**D'ALBORA MARINA REFURBISHMENT
THE SPIT, MOSMAN**

ACCESSIBILITY REVIEW

Morris-Goding Accessibility Consulting

16th November 2007

job no	DMS	drawing no	DA02
drawn	cc	issue	G
checked	mmk		
scale	1:200		
@	A1

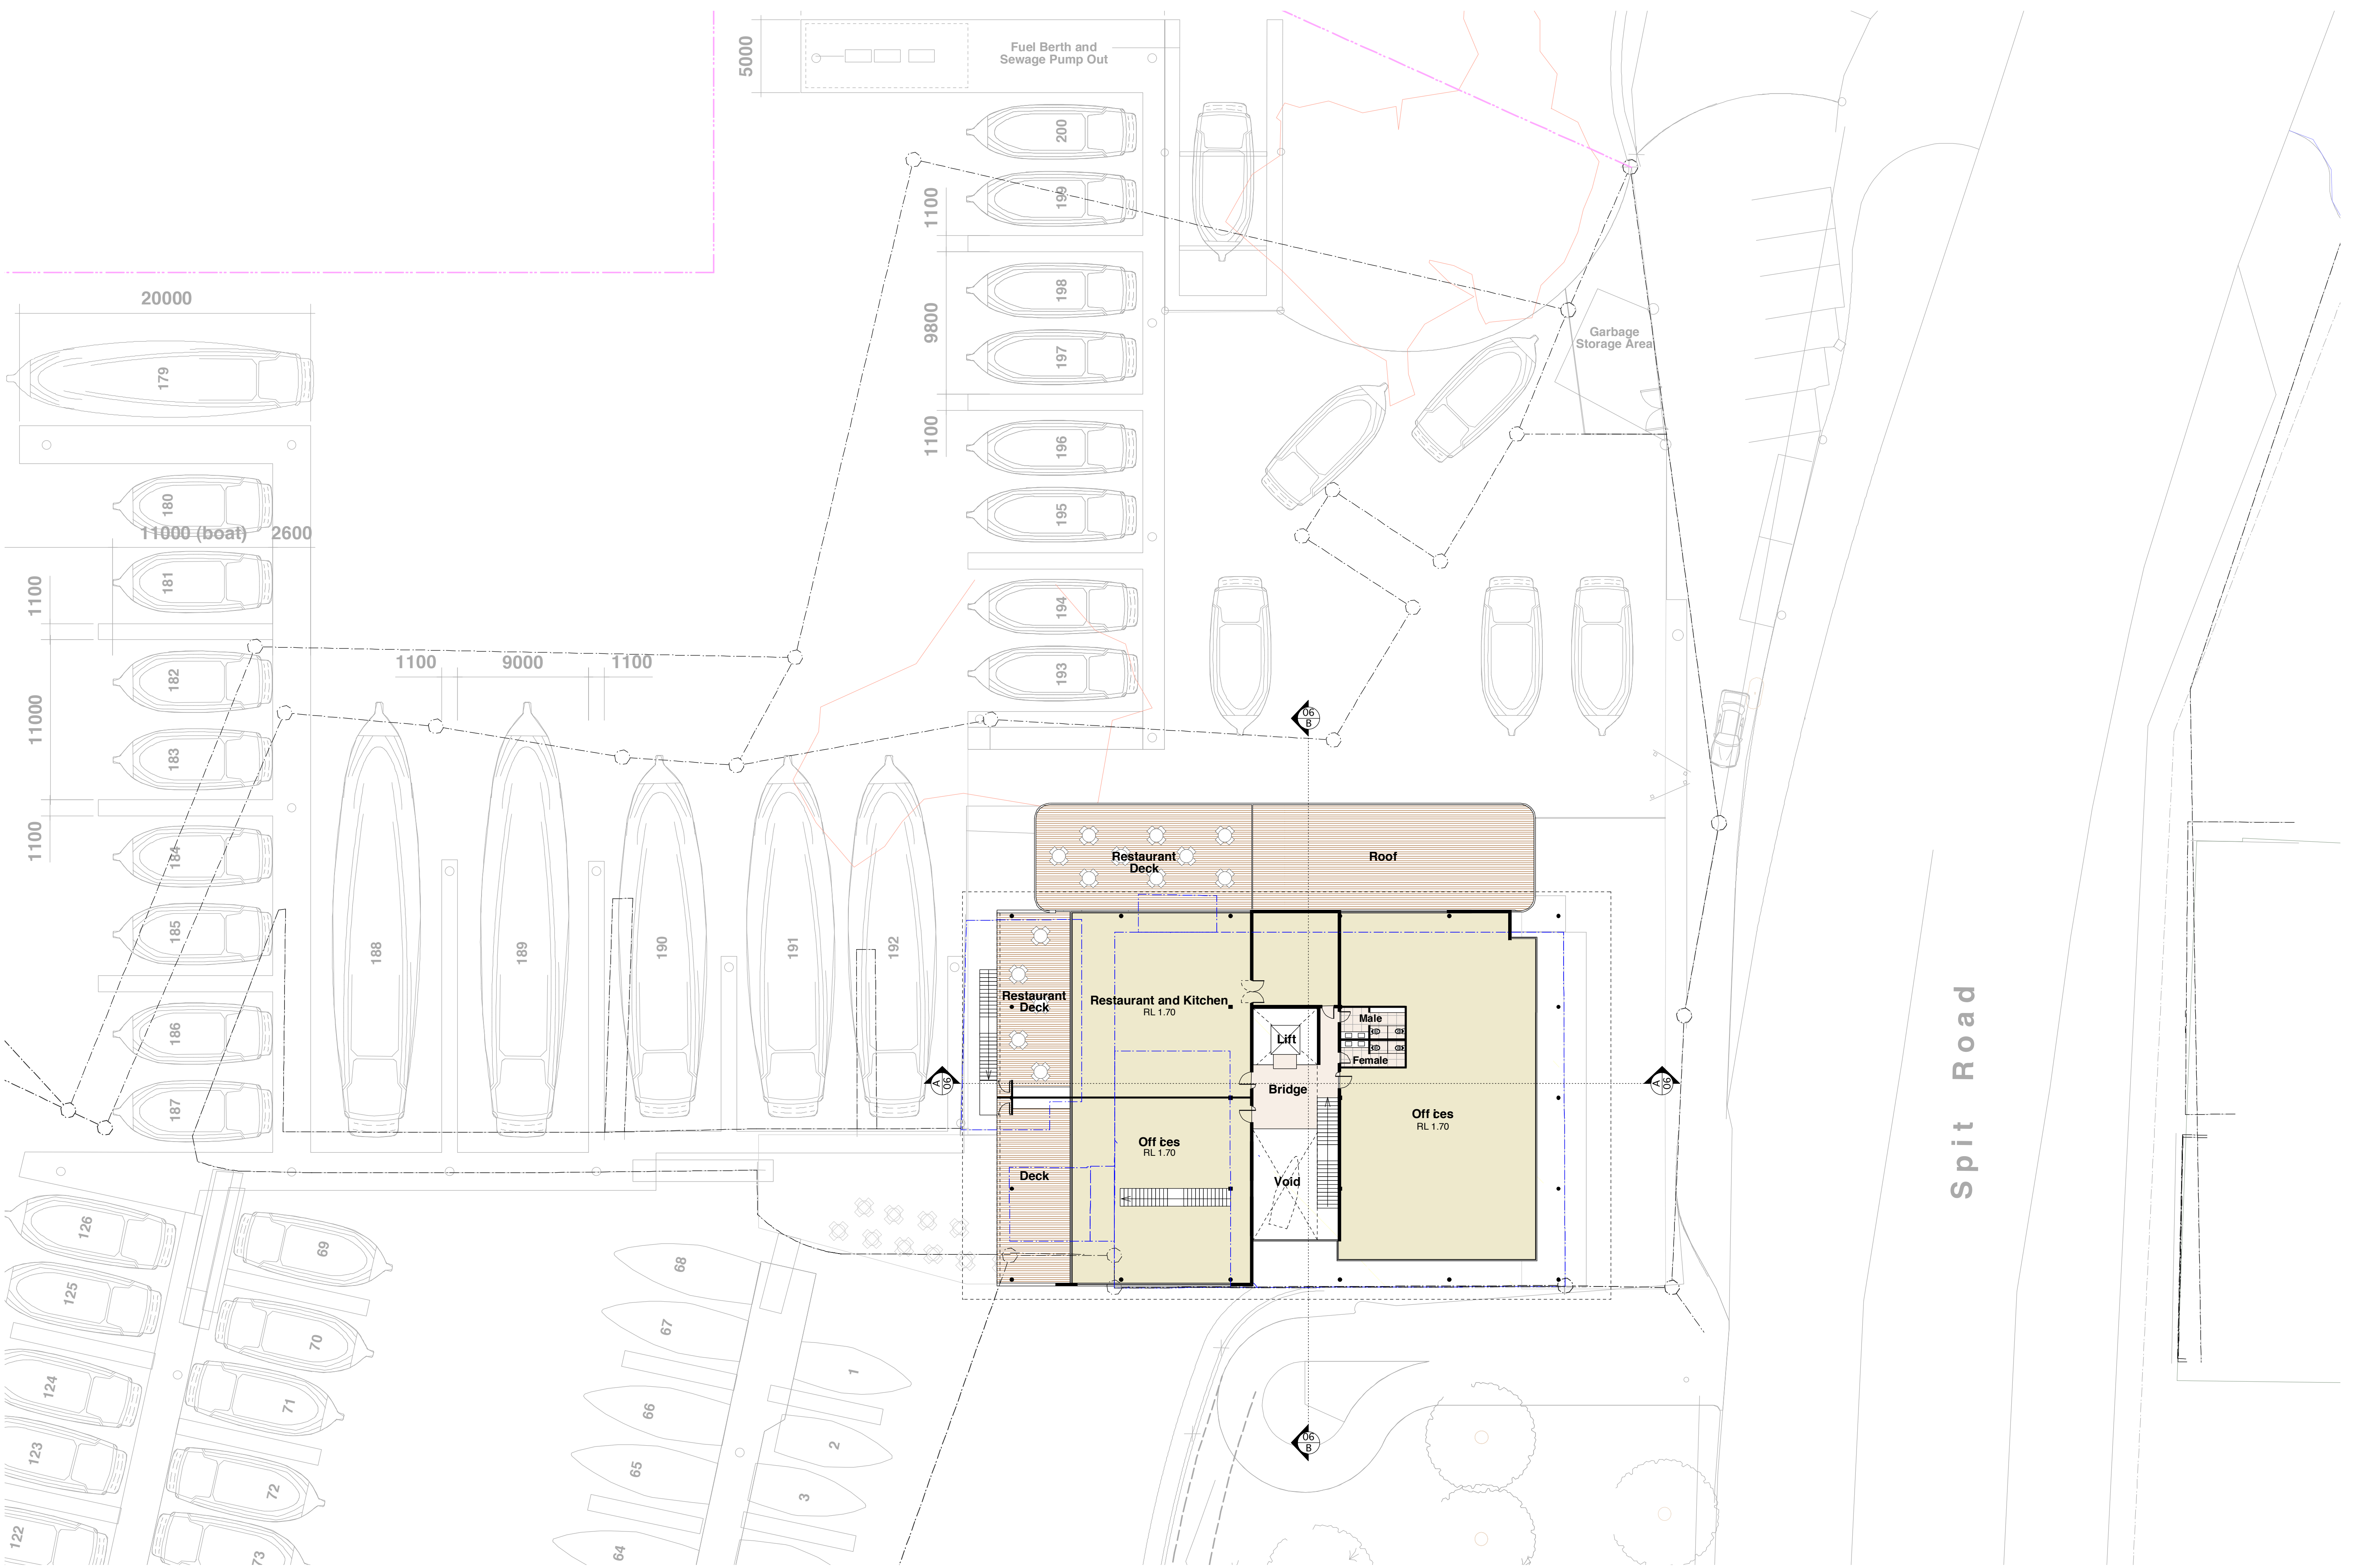
The lift has internal dimensions 1400mm x 1000mm which is too small and does not comply with AS1735.12.

- (i) Ensure the lift is upgraded such that the lift car has internal dimensions of at least 1400mm x 1100mm in accordance with AS1428.1. Best practice dictates that internal dimensions of 1700mm by 1400mm in accordance with AS1428.2.
- (ii) Ensure there is a minimum 500mm circulation area from the lift call buttons on the ground floor to the nearest internal corner (or stair in this case).
- (iii) Ensure the control panels, components and internal fitout of the lift car comply with AS1735.12

- (i) The entry door to tenancy 6 on the upper floor requires an external latch side clearance of 460mm to comply with AS1428.1.
- (ii) Ensure all internal doorways have minimum clear width of 850mm (920mm door leafs) in accordance with AS1428.2
